# PARAGON HIGHWAYS

## Proposed Petrol Filling Station

Mitchells Way, Barnsley

Designers Response to Stage 1 Road Safety Audit carried out by AC Road Safety Audits

13.6m OIL TANKER
OVERALL LENGTH 13.600m
OVERALL WIDTH 2.500m
OVERALL BODY HEIGHT 2.704m
MIN BODY GROUND CLEARANCE 0.419m
TRACK WIDTH 2.450m
LOCK TO LOCK TIME 4.00s
KERB TO KERB TURNING RADIUS 6.670m

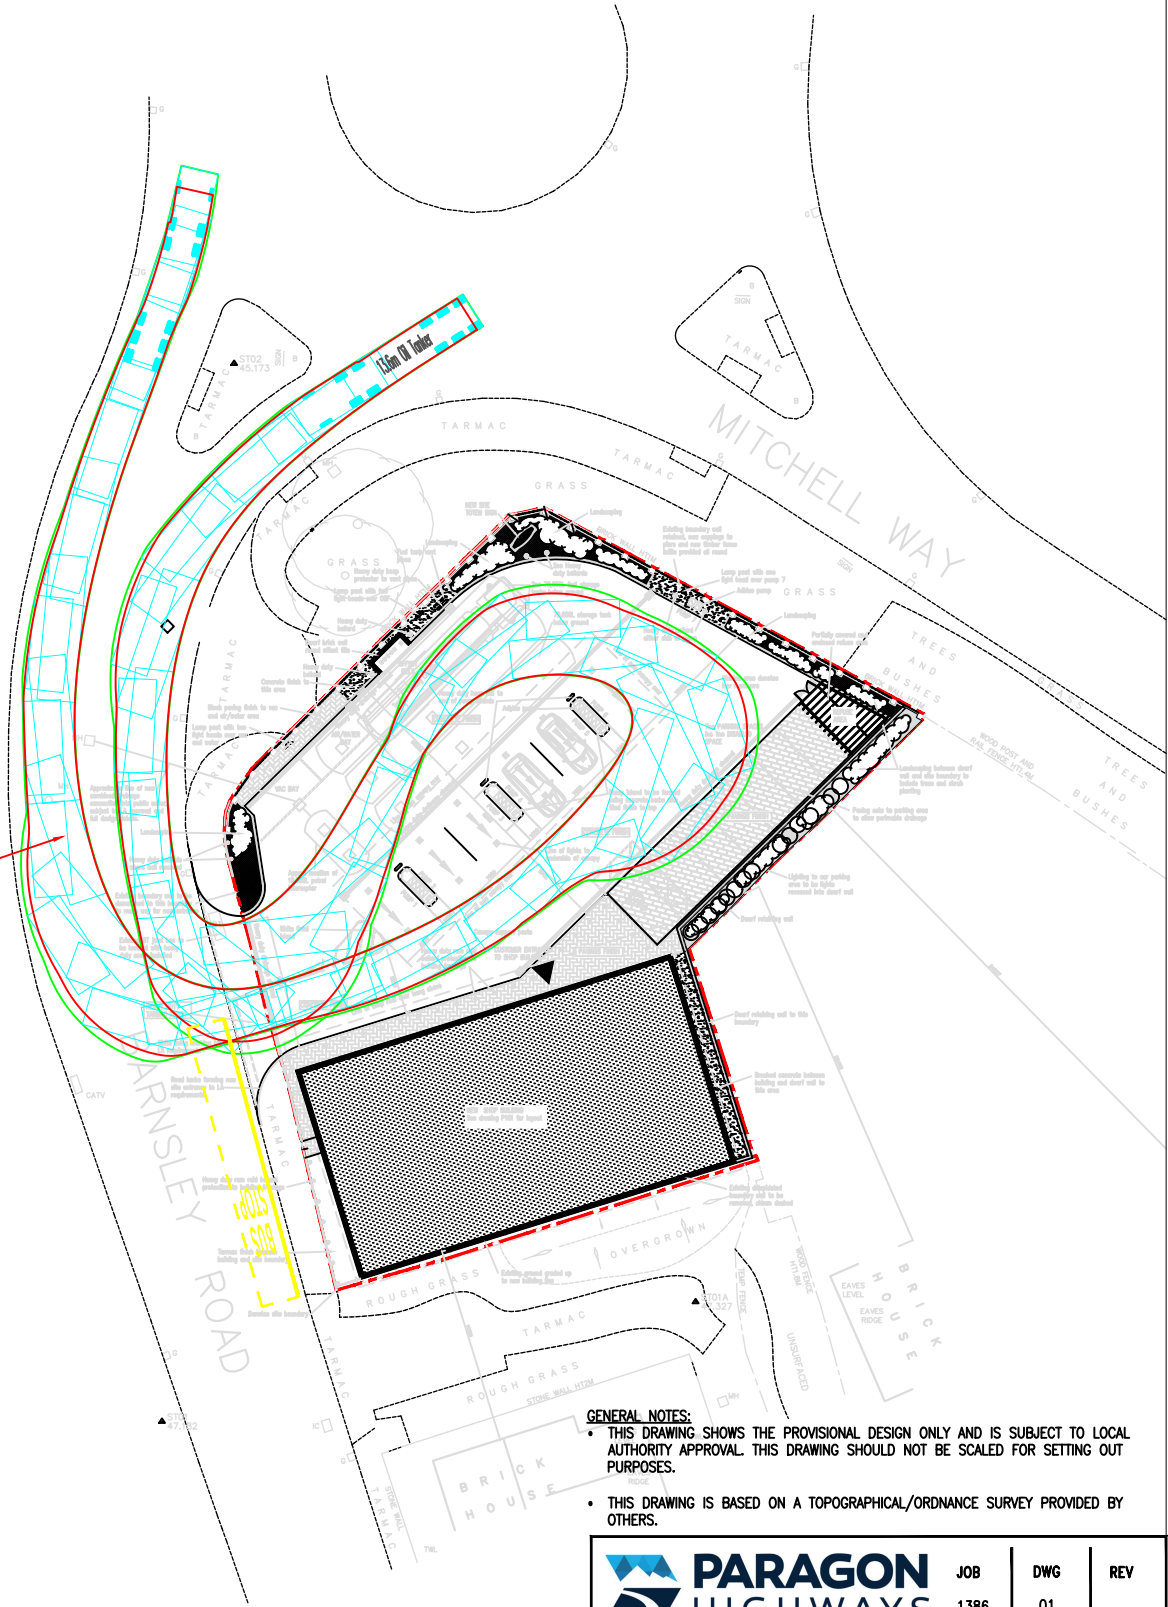
**Designers Response:** Vehicle tracking has been provided demonstrating that a large oil tanker can enter and exit the site in a forward gear. The swept path analysis identifies that suitable clearance is provided between the vehicle swept path and adjacent object/ feature. The size of tanker at the site could be conditioned if necessary. It should also be noted that during delivery times the petrol filling station would be closed to customers.
